Rezoning Transportation Analysis

Petition Number: 2025-009

Revision Log:

Date	Description
03-26-25	First Review (CM)
04-24-25	Second Review (CM)
07-24-25	Third Review (CM)
08-26-25	Fourth Review (CM)

Exhibit A

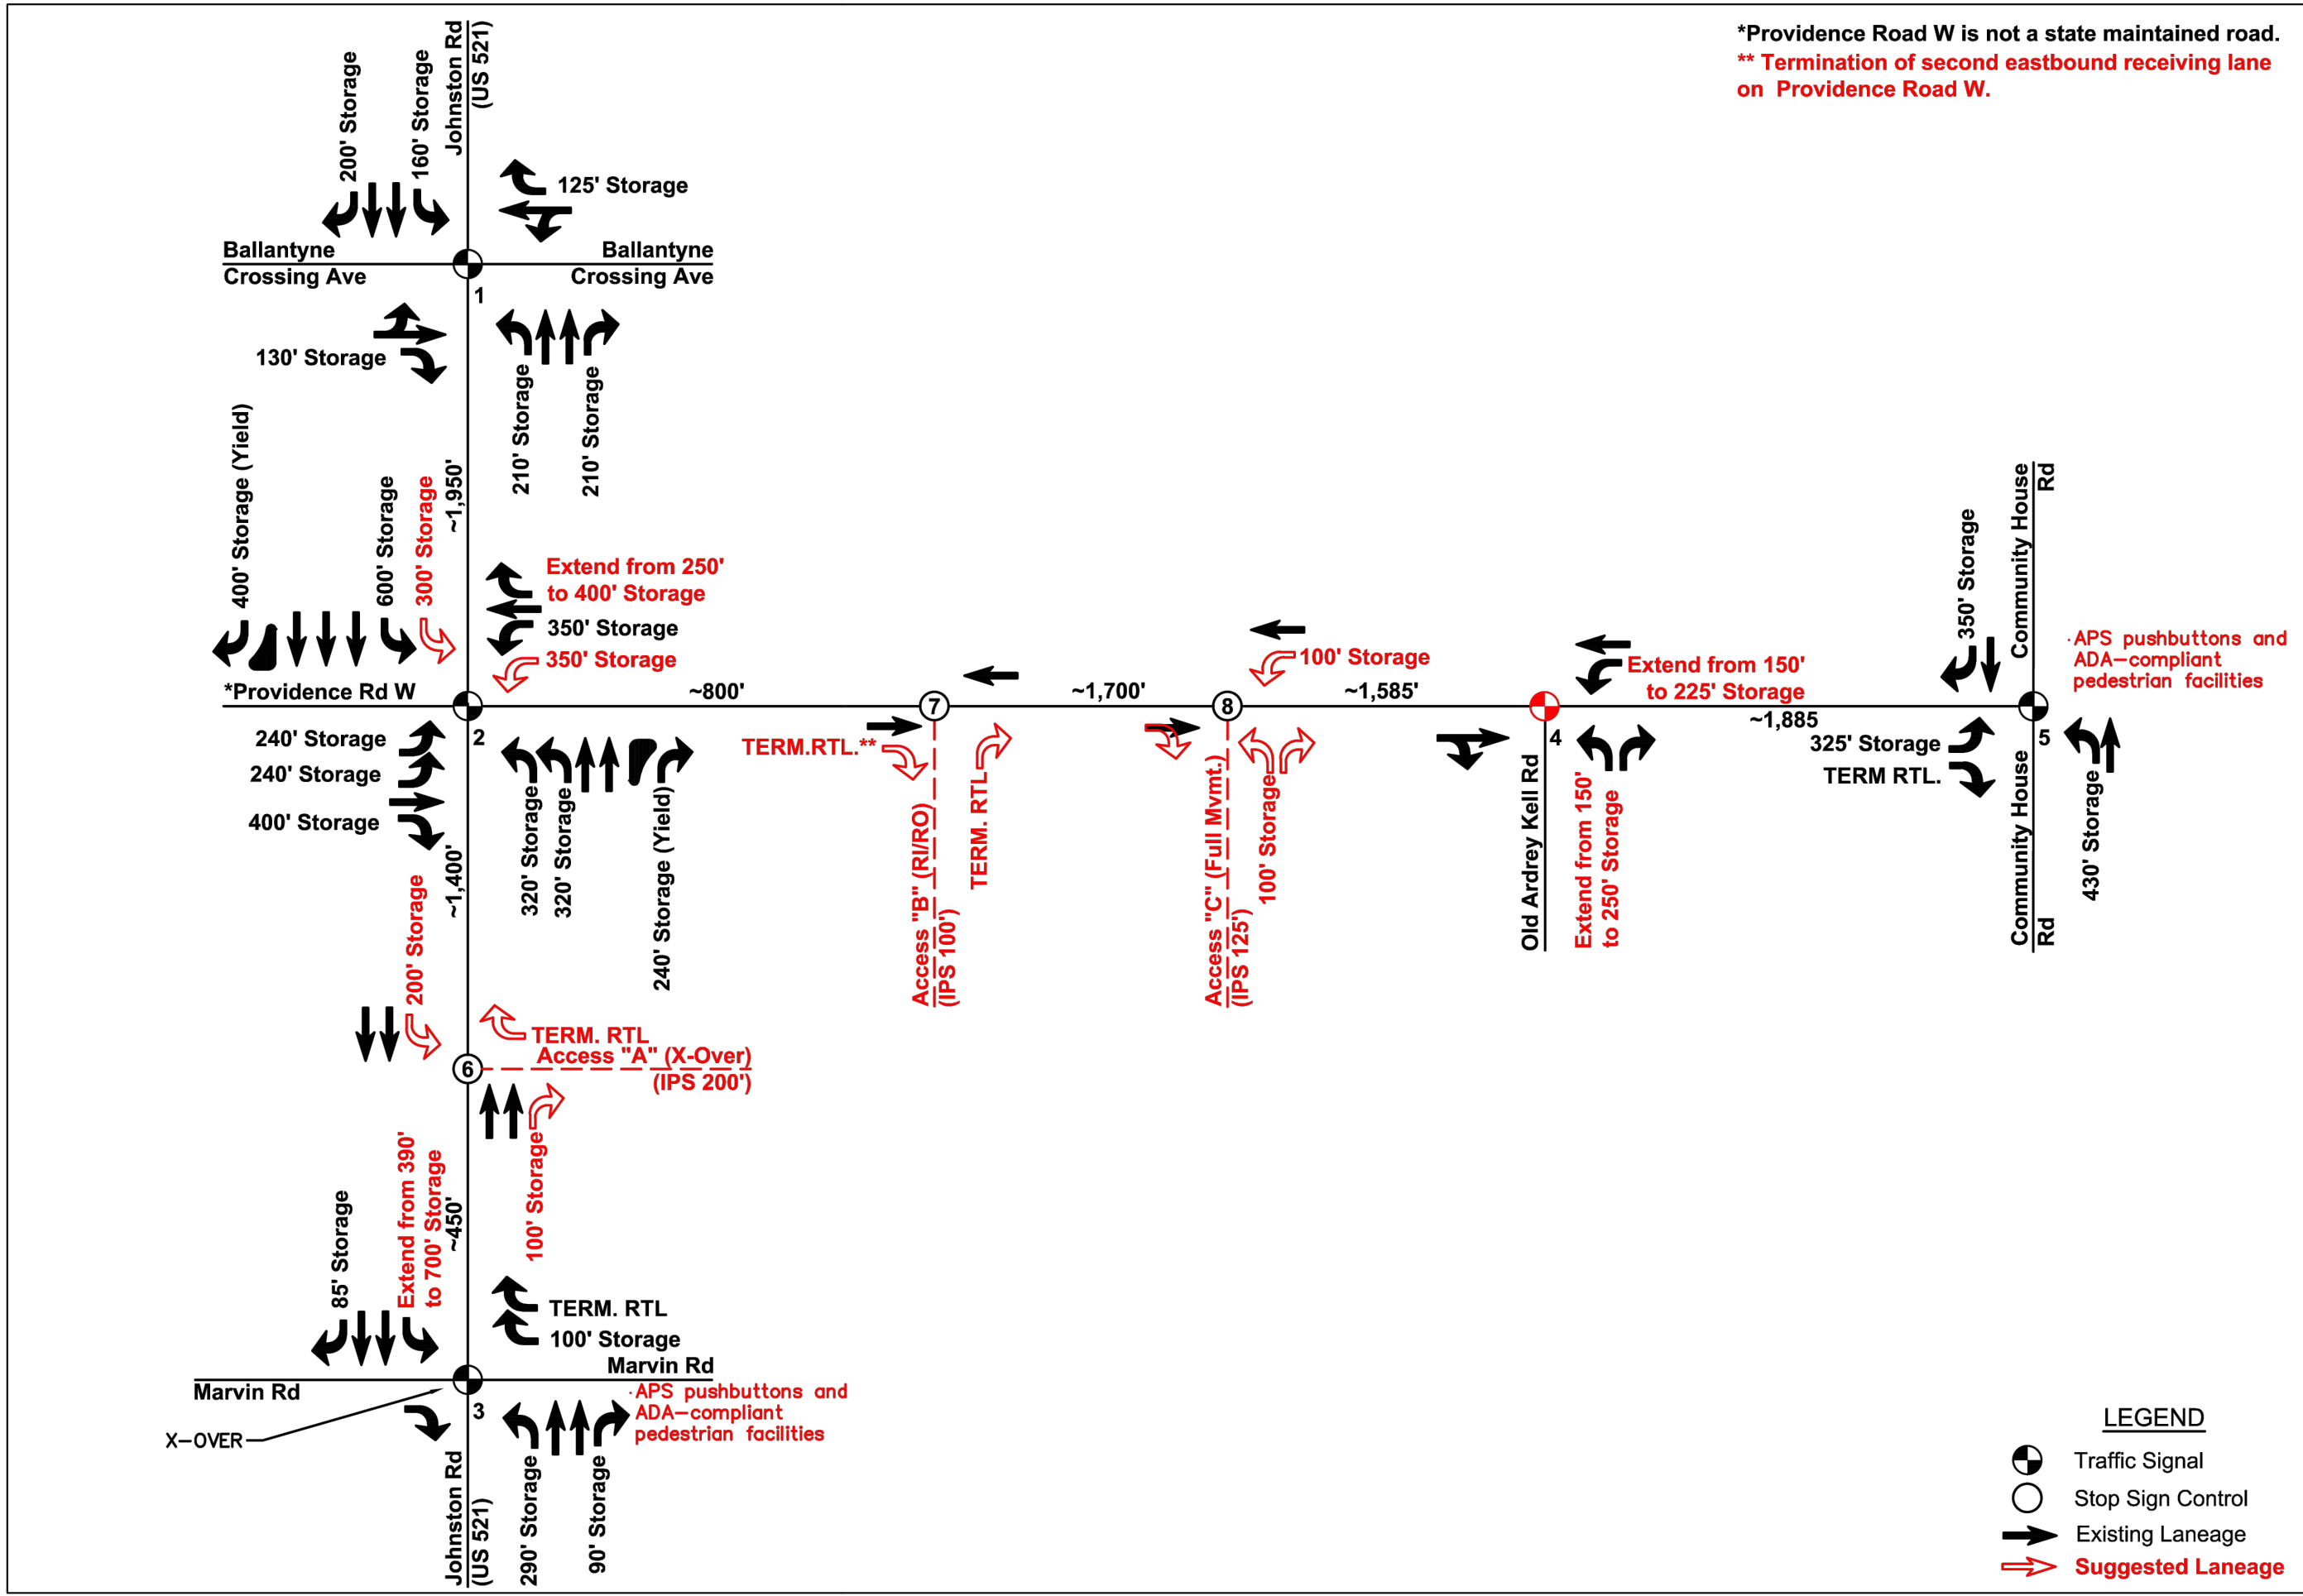
1. Revise site plan and conditional note(s) as needed per the updated Traffic Impact Study (TIS).

Outstanding Comment: 4.24.2025: address original comment.

Clarifying Comment: 7.24.2025: update the site plan and exhibit A to show the new leftover per updated TIS at Access "B".

Outstanding Comment: 8.27.2025: update Exhibit A on sheet 2 with the approved TIS information showing the modification to Access "B".
